Acceptance of Applications Checklist

Immingham Green Energy Terminal Section 55 Acceptance of Applications Checklist

Drawing Number	Rev
60673509-ACM-GEN-ZZ-DR-TP-0054 <small>Infrastructure Planning (Applications: Prescribed Forms and Procedure) Regulations 2009 REGULATION 5(2)(j)</small>	4

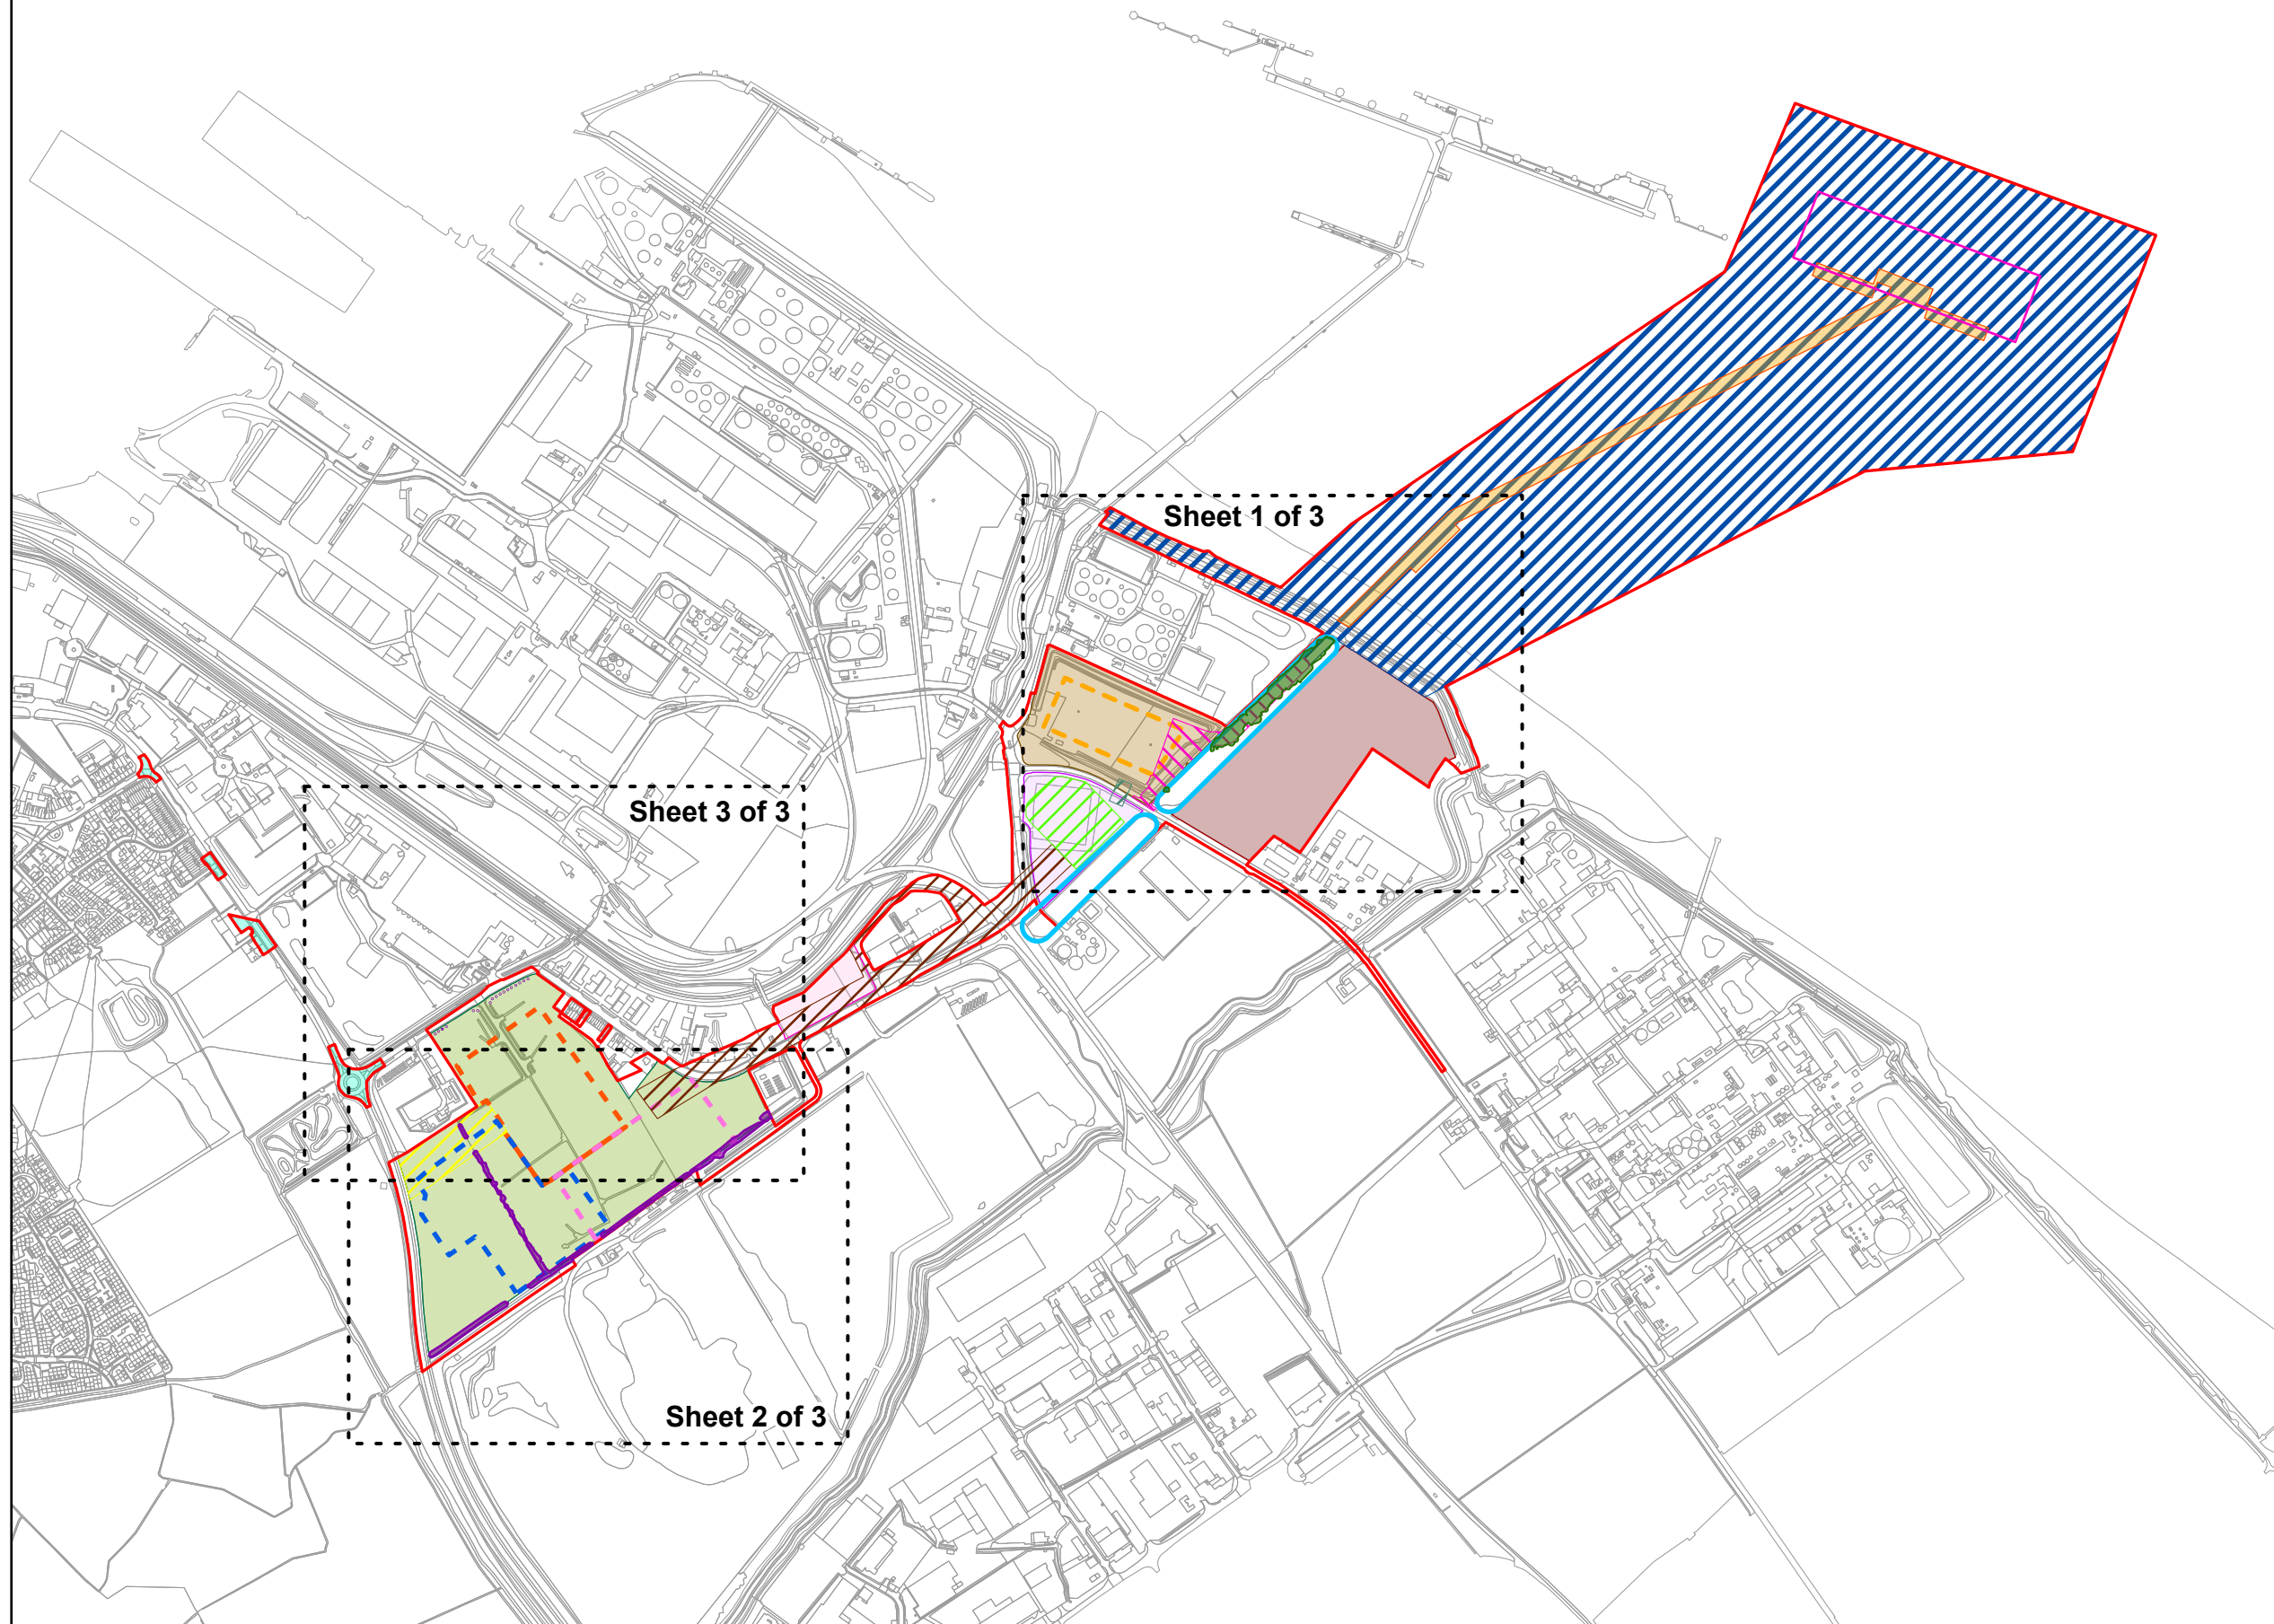
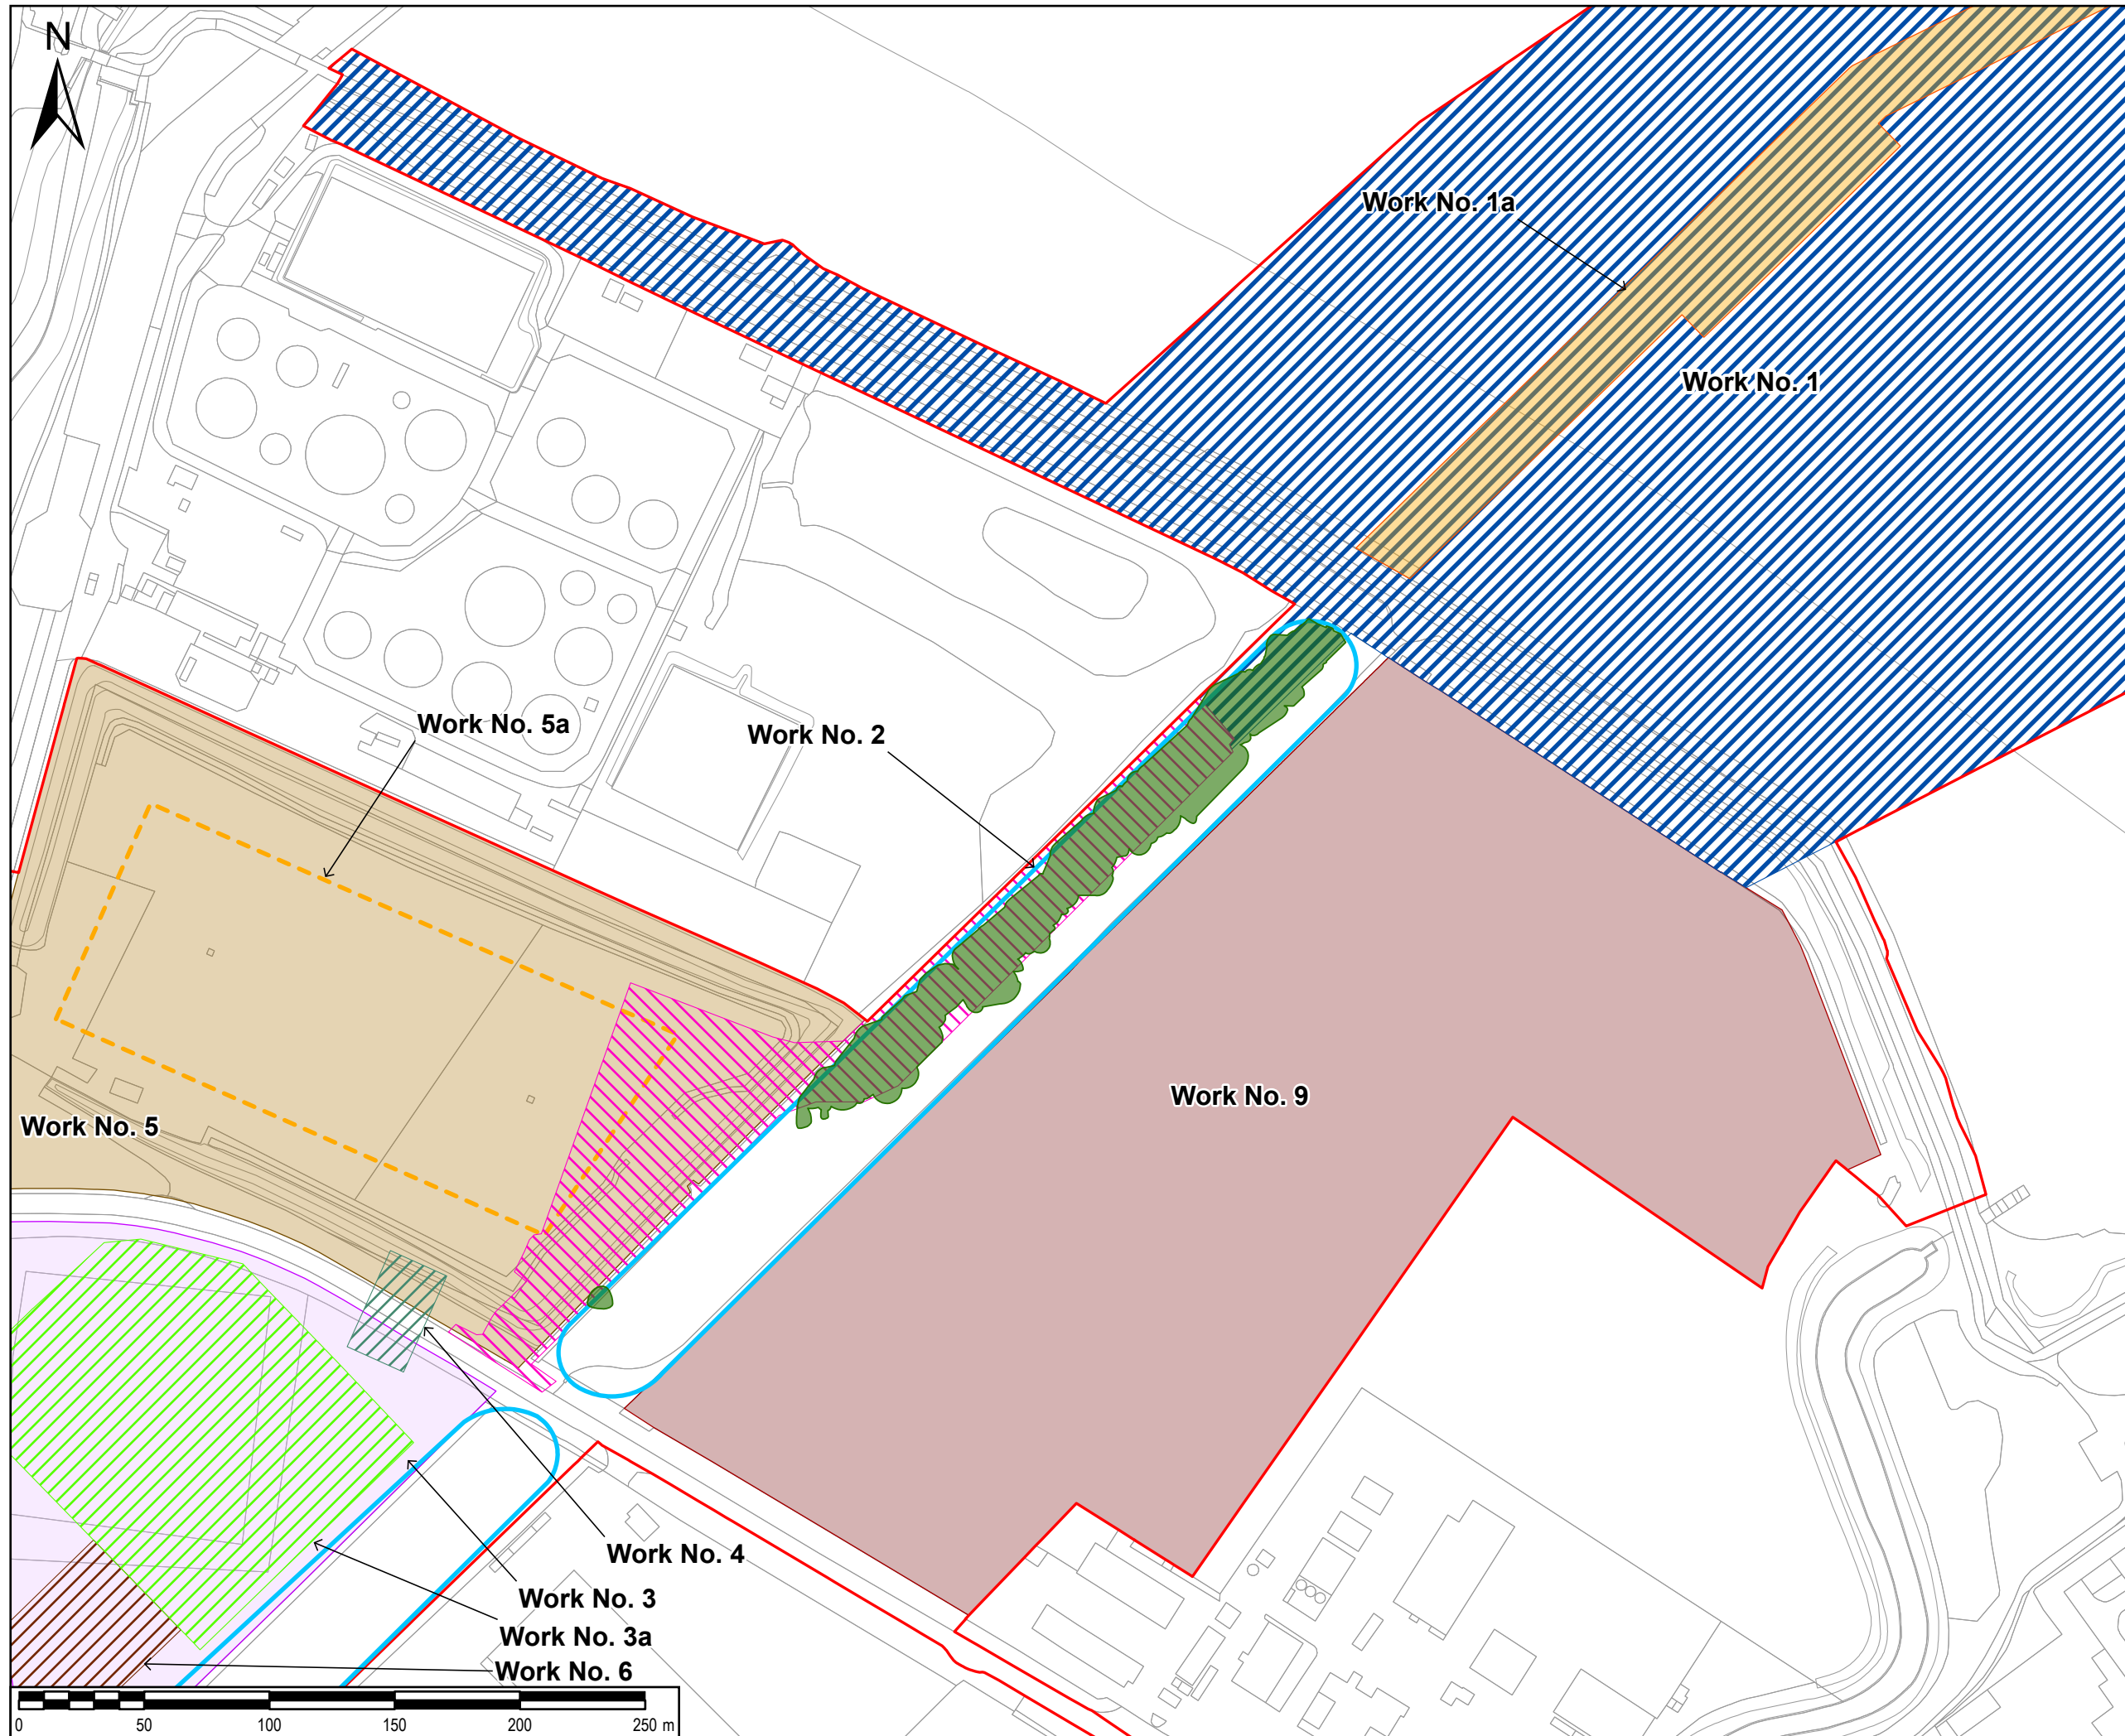
The Plan of Potentially Affected Hedgerows and Trees Subject to Preservation Orders Key Plan is attached to the end of the Traffic Regulation Measures Plan. It should be removed.
